From: Anita Gardner <Anita.Gardner@arun.gov.uk>
Sent: 24 December 2019 09:59
To: Planning.Responses <Planning.Responses@arun.gov.uk>
Subject: FW: Arundel Road - A/150/19/DOC

From: Mark Warwick <Mark.Warwick@arun.gov.uk>
Sent: 20 December 2019 17:15
To: James Elsey [REDACTED]
Cc: Anita Gardner <Anita.Gardner@arun.gov.uk>; Tracey Headley-Smith <Tracey.Headley-Smith@arun.gov.uk>
Subject: RE: Arundel Road - A/131/16/OUT

The photographs appear to show adequate fencing, but clearly this is only for part of the site and not the whole – so is not adequate for me to recommend a discharge of condition 10 (A/150/19/DOC).

Drawing Title	
Detailed Tree Protection Plan	
Client	Date
GD Group	22.10.19
Project	Drawing Ref
Arundel Road, Angmering	DTPP
Scale	Job Number
1:250@A2	1911
Drawn	
JLD	
The Urban Forest Consultancy	
W www.ufc.co.uk E joerning@ufc.co.uk M 07568021537

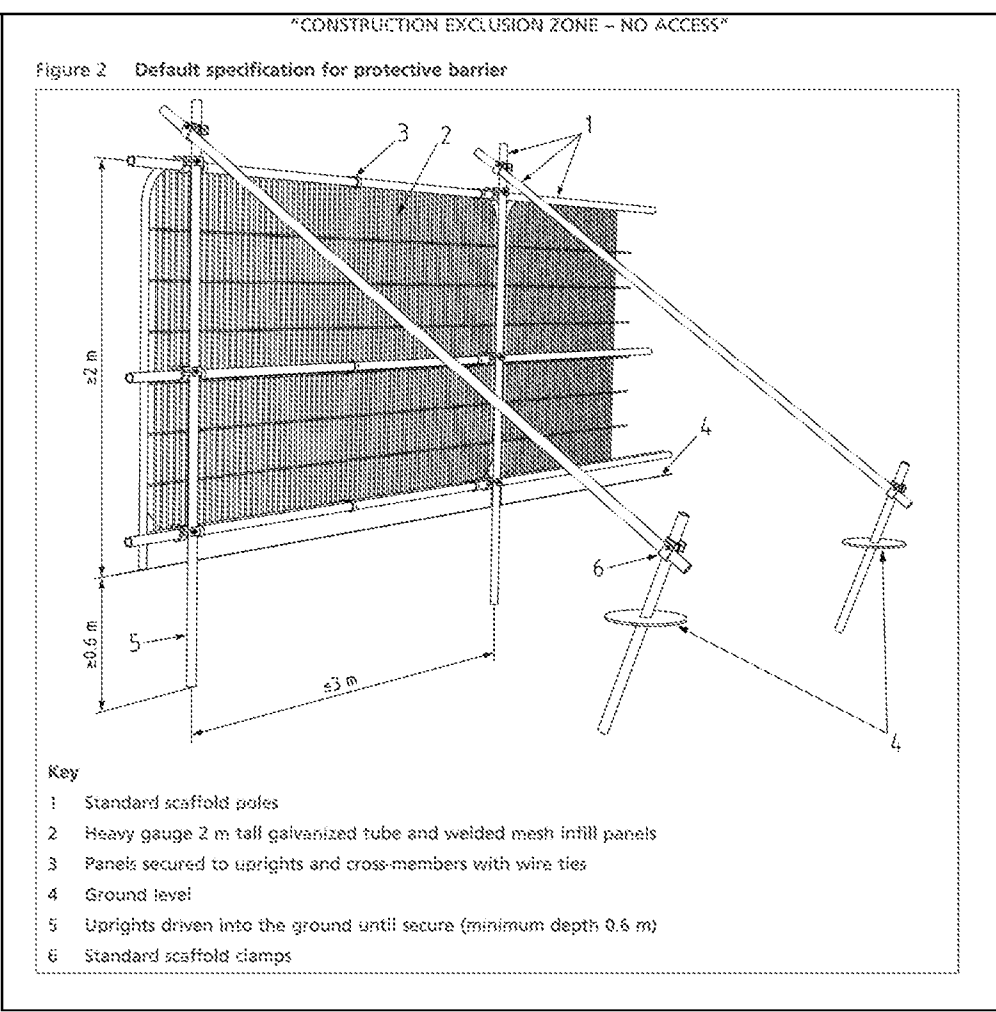
Are you satisfied that ALL the tree protection fencing has been installed correctly and at the locations shown on the approved plan?
